WST20/00369/02 | SF2020/148390

SSD-9451258: Environmental Impact Statement for the Forest Glen Solar Farm

Thank you for the request for review of the Environmental Impact Statement (EIS) for the Forest Glen Solar Farm development (SSD-9451258) via the Major Projects Planning Portal on the 1 December 2021.

B-Double (26.0m)	26.000m
Overall Length	2.500m
Overall Width	4.300m
Overall Body Height	0.540m
Min Body Ground Clearance	2.500m
Track Width	6.00s
Lock-to-lock time	15.000m
Curb to Curb Turning Radius

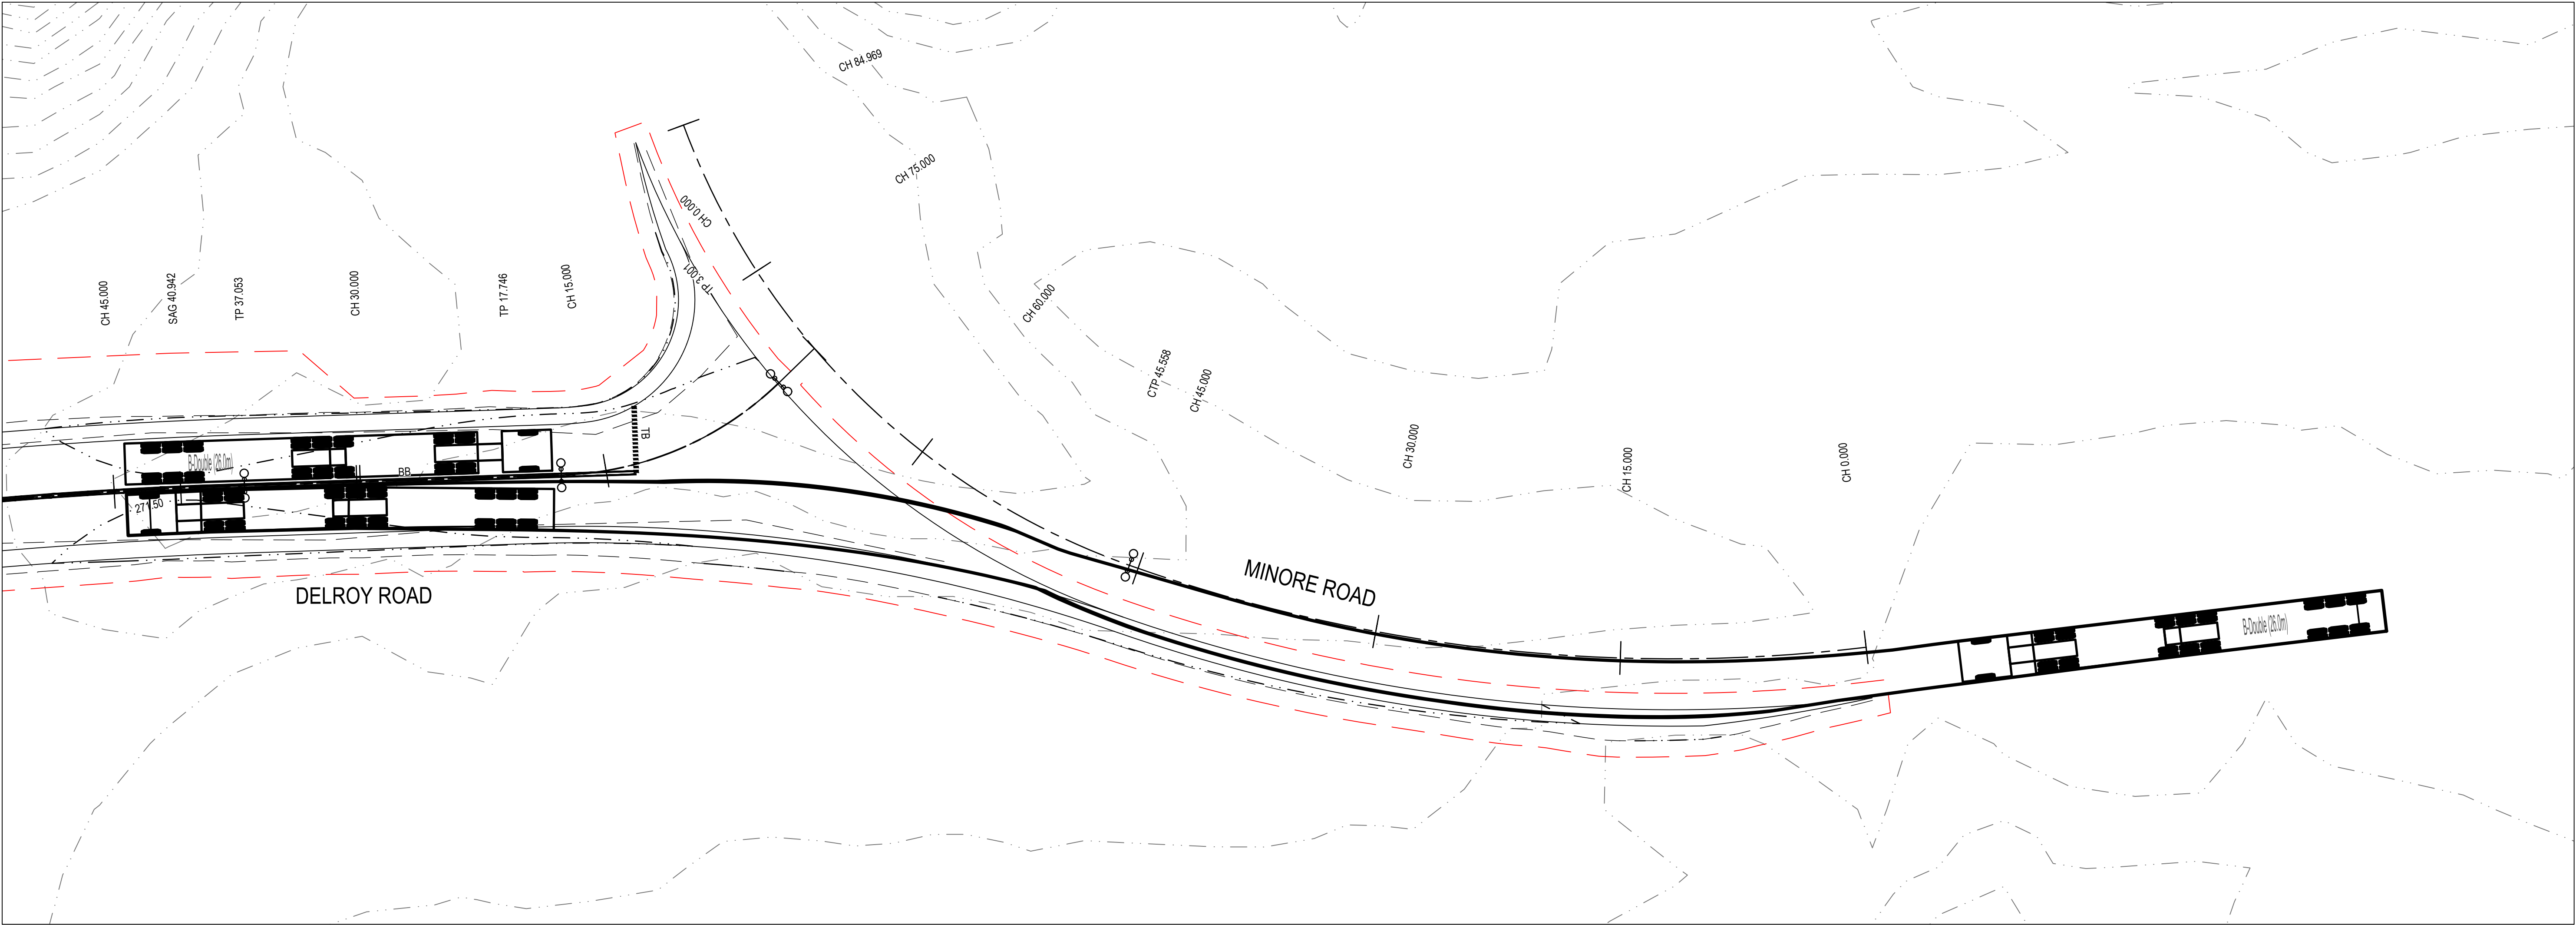
- A breakdown of the traffic count survey undertaken on Tuesday 8 December 2020 is required to clearly demonstrate the peak periods.
- A swept path analysis on scaled plans is required in accordance with Austroads turning templates to demonstrate that the largest vehicle likely to utilise the Newell Highway/Minore Road intersection (and any other intersection proposed for access) can perform all manoeuvres throughout the intersection.
